TO: Community Development Services
FROM: Public Works Planning Review Team
DATE: March 9, 2021
SUBJECT: CU-21-00001 Siderits Storage

The Department of Public Works has reviewed the permit for the Siderits Storage Conditional Use Permit and has the following comments:

7-90 STORAGE
PARCEL 80-11-11-20-0-0
EASTON, KITTEN'S Co., WA
SCALE 1" = 25' PARCEL 2816.34

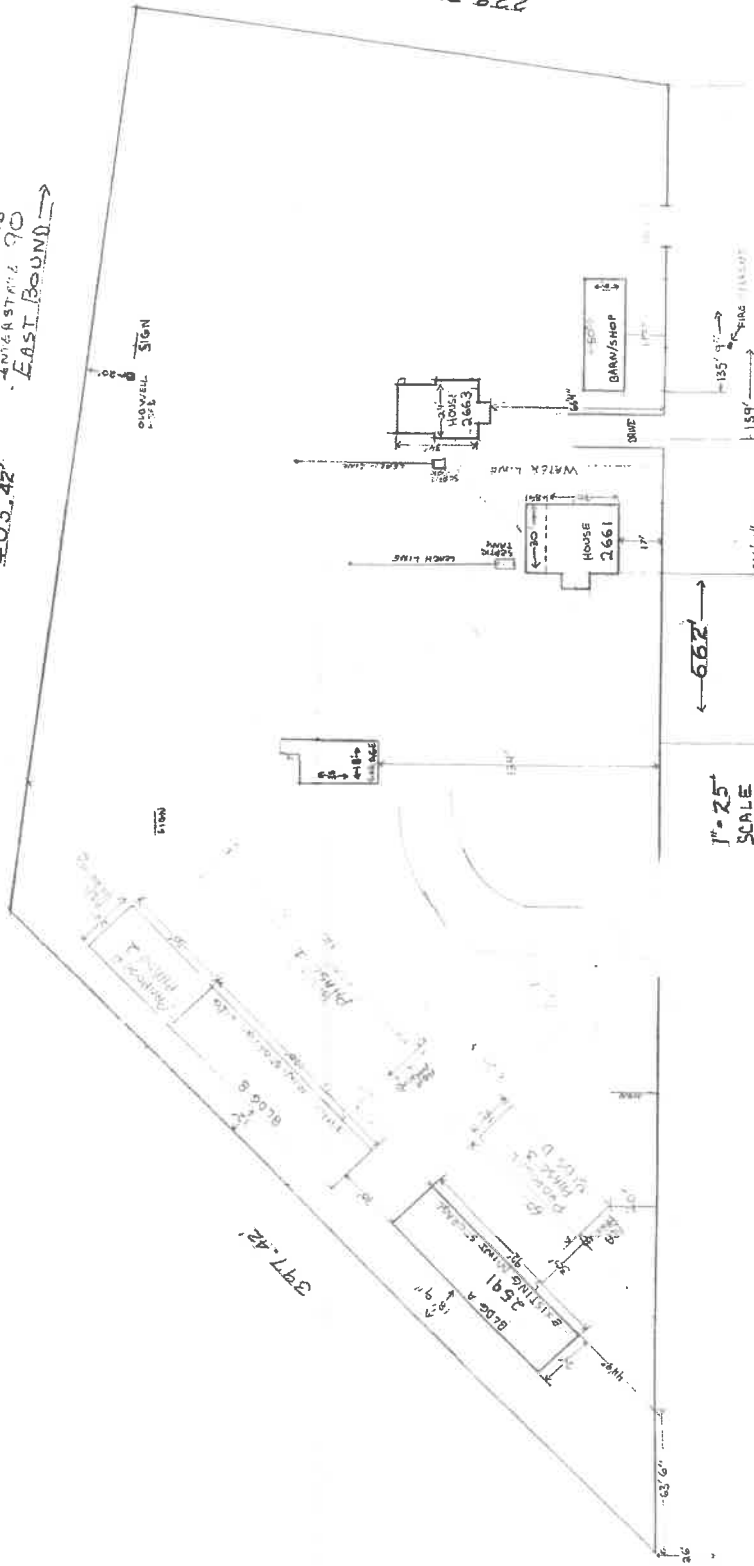
- A. Access permit required: The Siderits Storage will require an access permit for a commercial entrance.
- B. Grading Permit: A grading permit is required for any dirt work exceeding 100 cubic yards of excavation and/or fill.
- C. Stormwater Plan: Engineered Stormwater plans are required if the project generates an impervious surface exceeding 5000 square feet. The stormwater system will comply with the Stormwater Management Manual for Eastern Washington.
